Our Case Number: ABP-310286-21

Re: Railway works and all works necessary to eliminate and, where necessary, upgrade seven numbered level crossings and carry out all associated and ancillary works along a 24-kilometre section of the Dublin to Cork Railway Line.
Fantstown, Thomastown, Ballyhay, Newtown, Ballycoskery (Ballyhea Village), Shinanagh and Buttevant, Co. Cork and Co. Limerick.

Railway Order – Dublin to Cork Railway Line (Eliminate and Upgrade of Level Crossings between Limerick Junction and Mallow) Order 2021 (XC201 Thomastown and the XC187 Fantstown)

Figure 2.3: XC187 Fantstown Proposed Solution

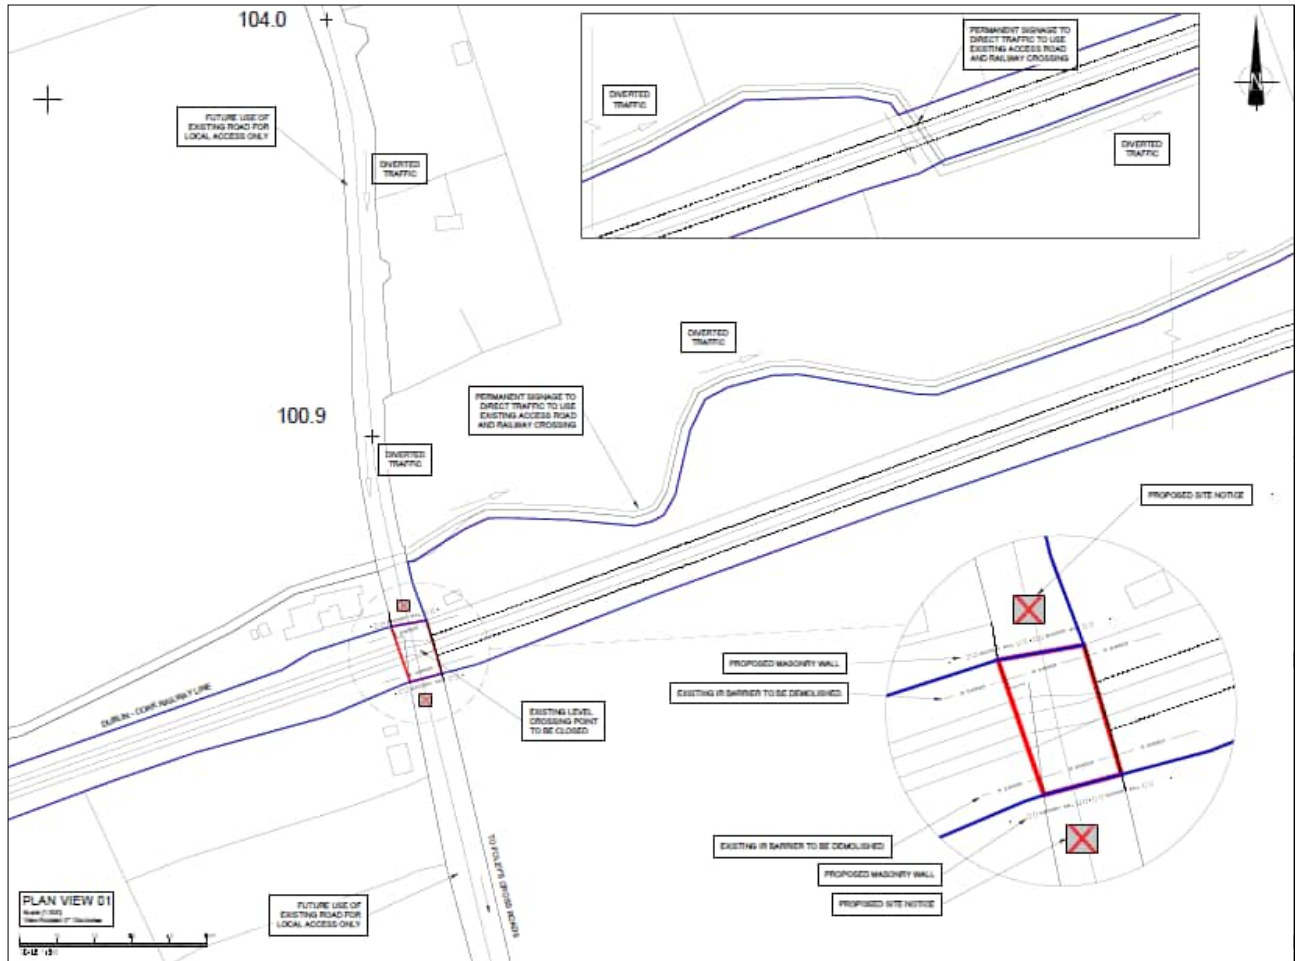
1. Division of the parish, including rural isolation.
2. Long delays and waiting times at the rail crossing.
3. The imminent closure would result in two cul de sacs.
4. Access for emergency services.

Figure 2.5: XC201 Thomastown Proposed Route Alignment

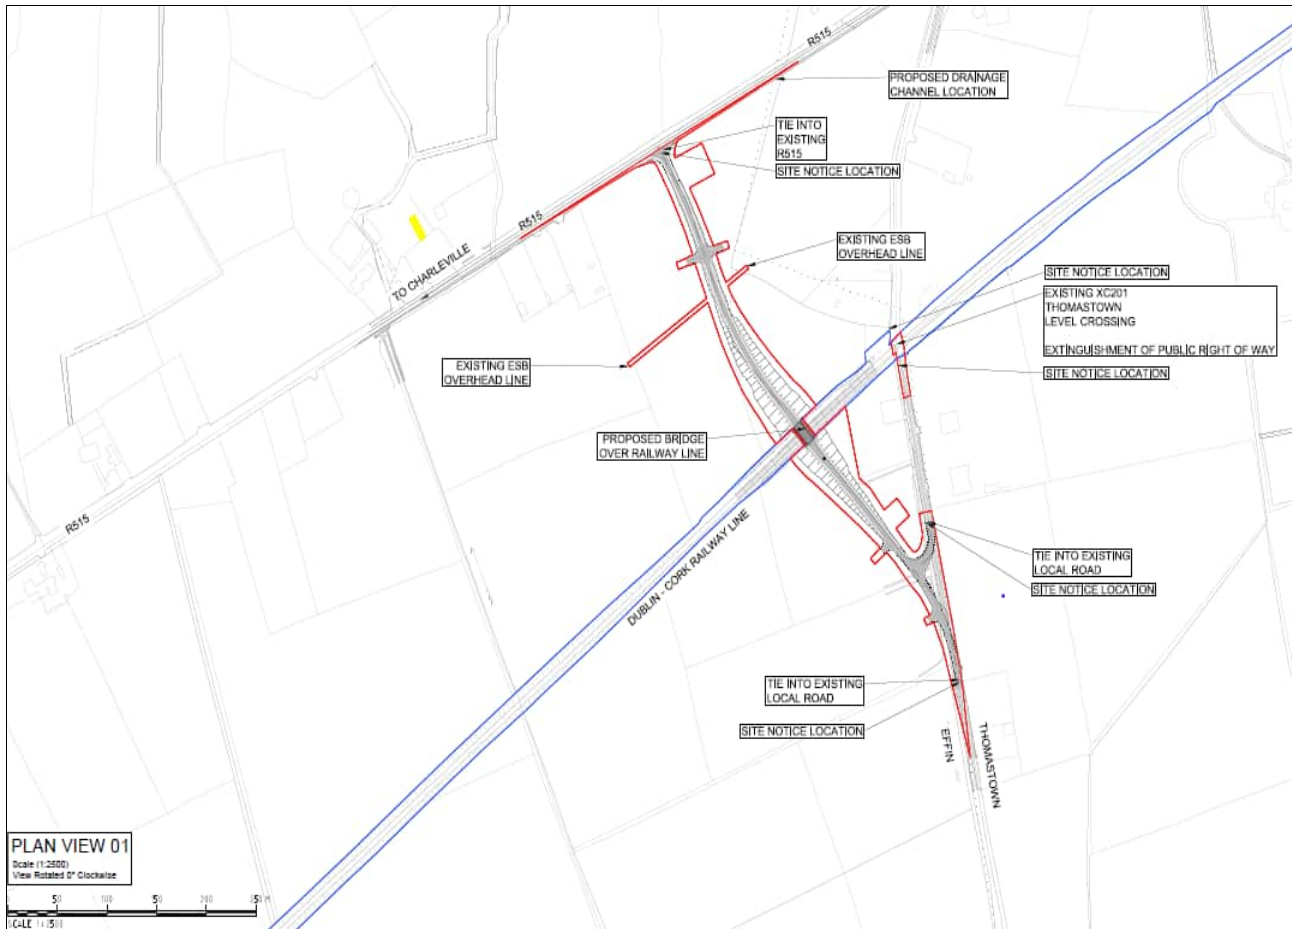
Concerns with the width of the road which is not wide enough for two vehicles to pass safely and as this is a rural area there are a number of farms in close proximity to the rail crossing with a significant movement of agriculture machinery, including milk trucks, animal feed deliveries, tractor and trailers during silage season etc. The volume of agricultural machinery will also increase on this road especially during the busy harvesting season which further outlines the importance of having a wider two lane road.

The new junction planned for the Charleville - Kilmallock road (R515) is designed in an unsafe way as it will cause stacking of cars when a vehicle is turning off the R515 onto the new road.

The Effin community has been linked by the railway crossing for a long number of years and the amenities and services are all on the south side of the railway crossing (i.e. primary school, GAA facilities, church etc.). This new road is a major step forward in uniting what was a divided Parish and the volume of traffic will increase tenfold at a minimum as a result of this proposed development and therefor in the interest of health and safety for road users a wider two lane road is essential.
